M25 junction 28 improvement scheme

TR010029

9.86 Applicant's comments on the London Borough of Havering's Deadline 5 submissions

April 2021

#### 9.59 Overlay plan of Plot 1/8 and the burial plots

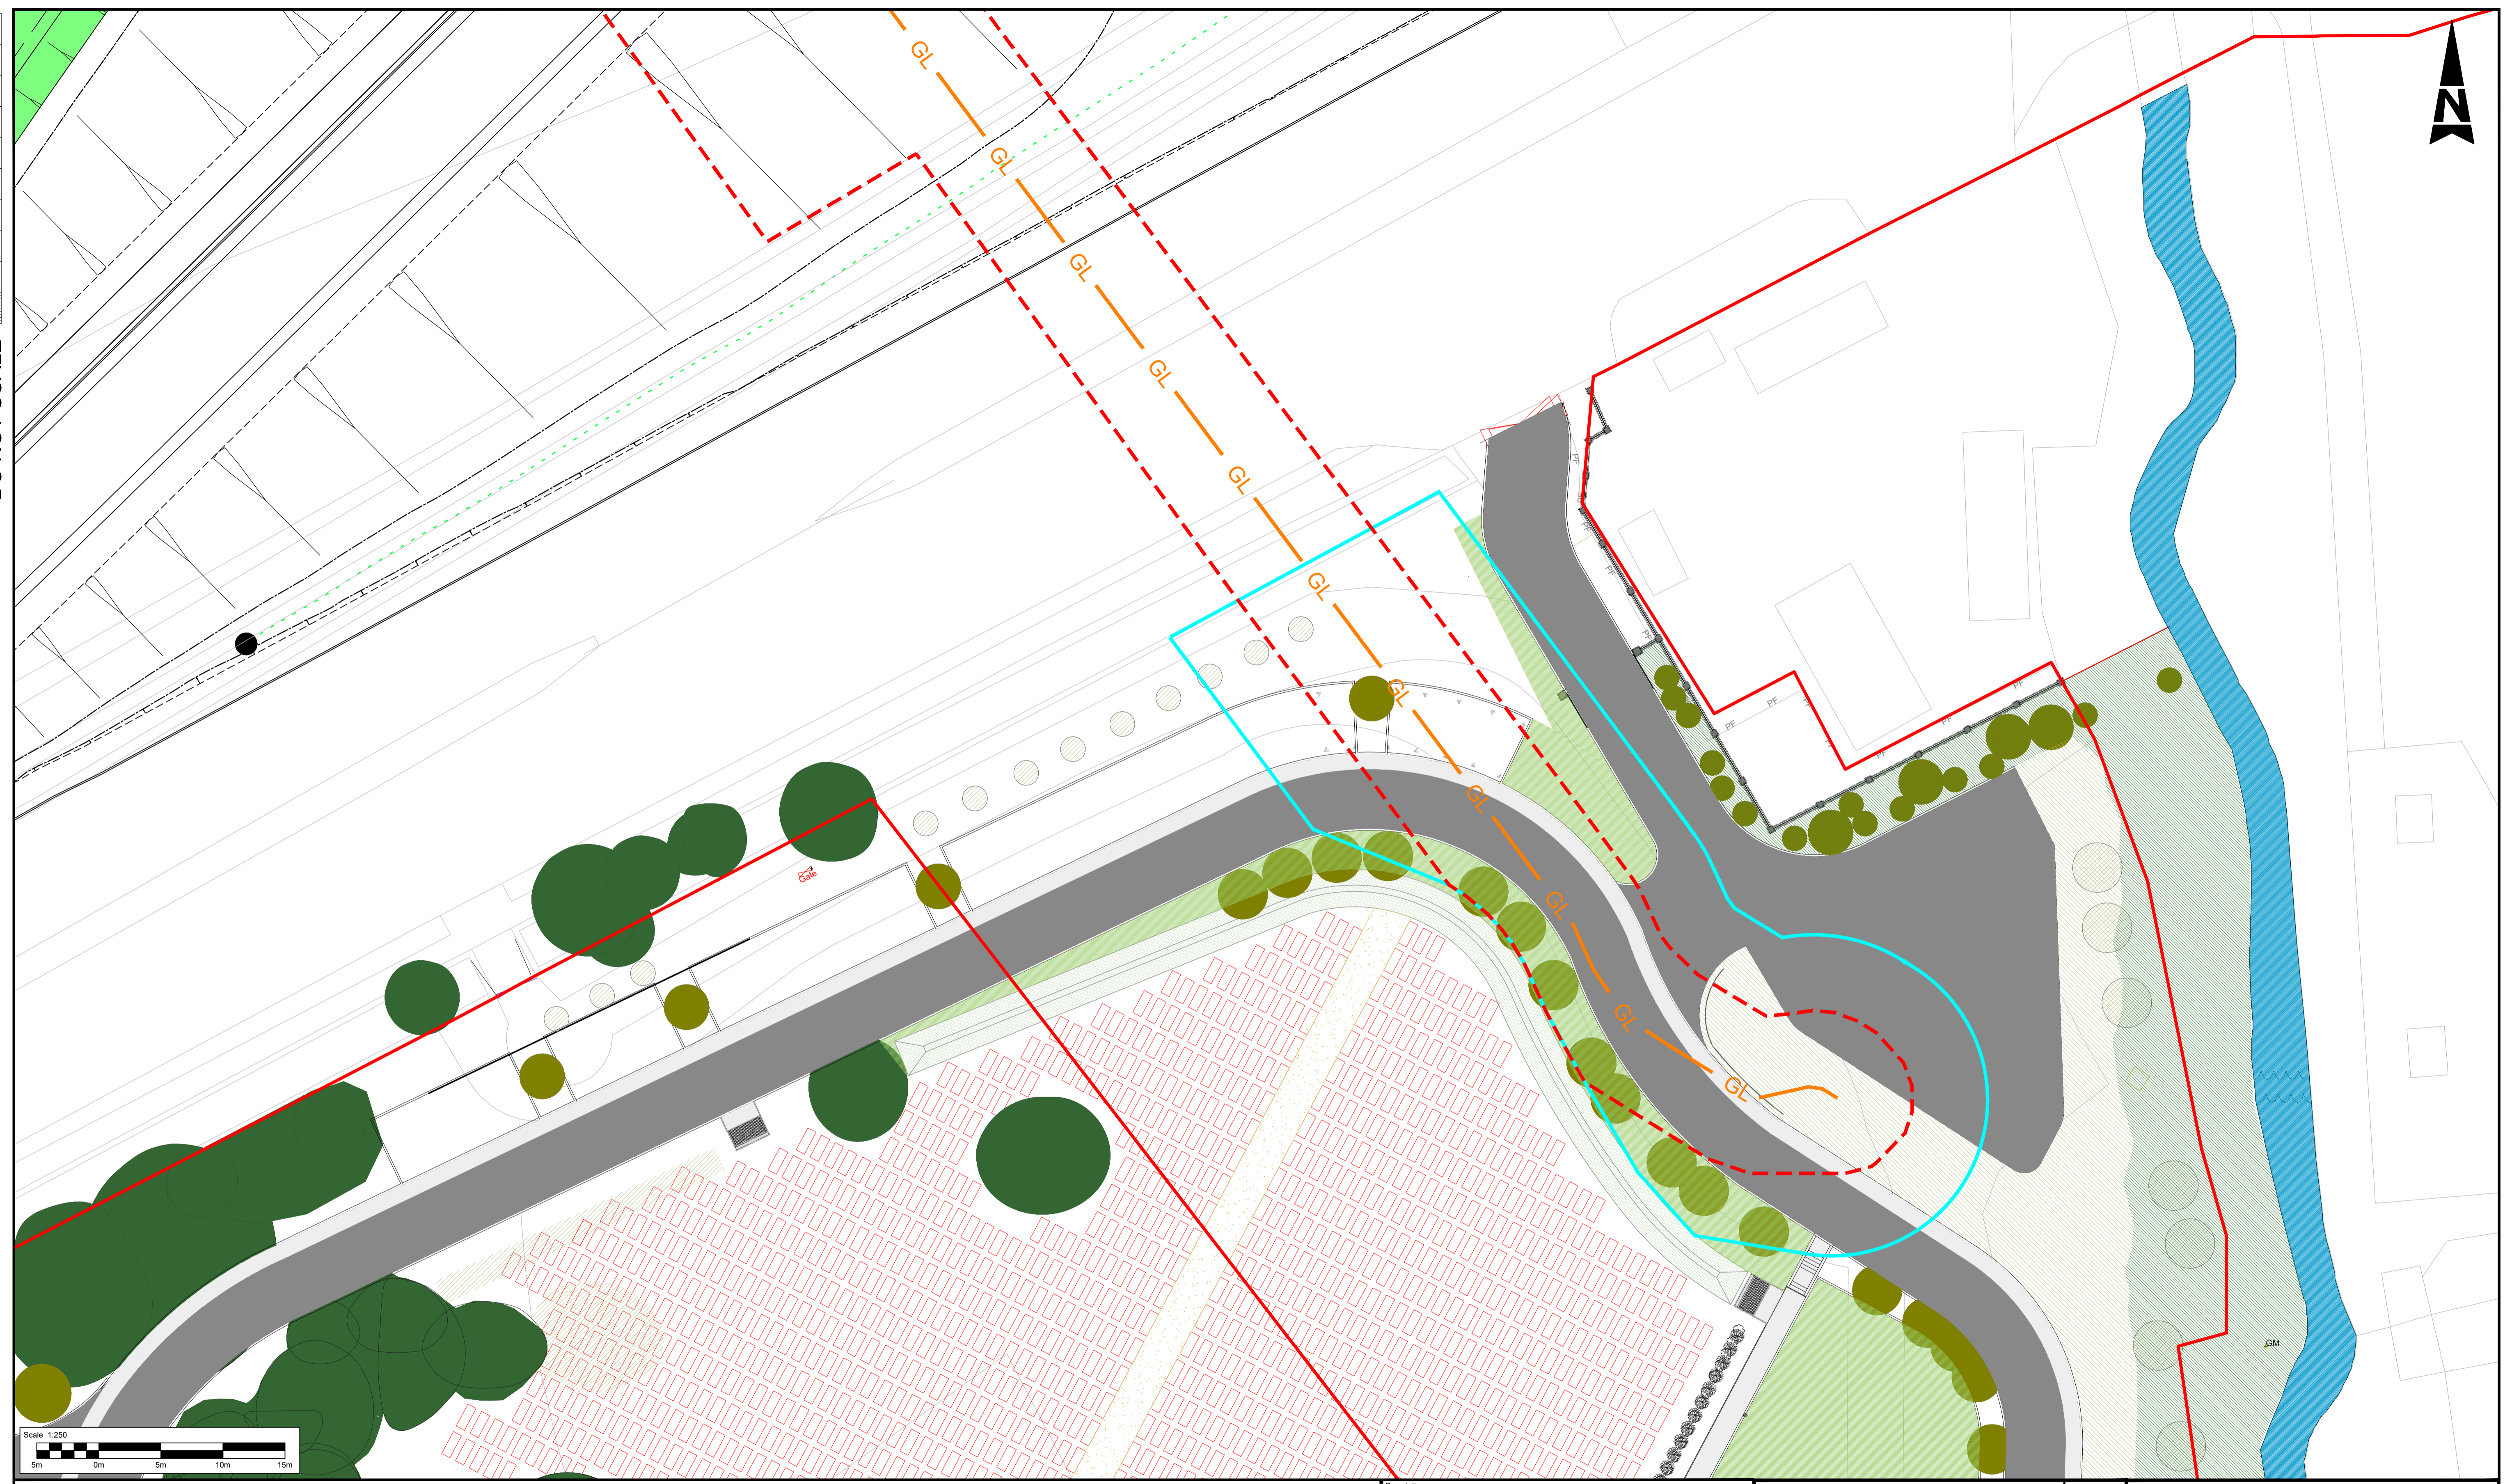
CA 2.3	<p>Following a request to do as Action Point 5 [REP4-018], the Applicant submitted a Gardens of Peace Muslim Cemetery Overlay Plan at Deadline 4 [REP4-020] in which it is demonstrated that Plot 1/8 would not extend over the burial plots.</p> <p>For the Applicant:</p> <ul style="list-style-type: none"> i. Explain how this plan is secured in the draft DCO [REP4-002] as a certified 	<p>LB Havering notes the submission by the Applicant at Deadline 4 of REP4- 018.</p> <p>LB Havering awaits confirmation of the views of the Gardens of Peace Cemetery and will update the ExA with regards to the Policy Compliance matter Havering has previously raised relating to the potential loss of burial plots, accordingly.</p>	<p>Please see response reference REP5-066-01 in Highways England's comments on the Gardens of Peace's response to the Examining Authority's Further Written Questions submitted at Deadline 6 (TR010029/APP/9.87).</p> <p>Highways England has provided a draft tri-party agreement with the Trustees of the Gardens of Peace (the Trustees) and Cadent Gas on 14 April 2021. Discussions are ongoing with regard to the draft agreement to satisfy all parties and Highways England is hopeful that an agreement will be reached by the end of the examination.</p>

REP5-058-02	<p>REP3B-006-2</p> <p>LB Havering notes that the Applicant has submitted at Deadline 4 (REP4-020) an Overlay of Works Plan showing Plot 1/8 and the burial plots at the Gardens of Peace Cemetery. It is further noted that draft Heads of Terms have been sent to the Gardens of Peace Trustees. Should the Trustees be satisfied with the information provided, LB Havering would consider that the scheme is in compliance with LDF policies CP8 and DC27.</p>	<p>Please see Highways England response to Gardens of Peace's response to ExAWQ2 submitted at Deadline 6 (TR010029/APP/9.87). Highways England provided a draft tri-party agreement with the Trustees of the Gardens of Peace (the Trustees) and Cadent Gas on 14 April 2021. Discussions are ongoing with regard to the draft agreement to satisfy all parties and Highways England is hopeful that an agreement will be reached by the end of the examination.</p>
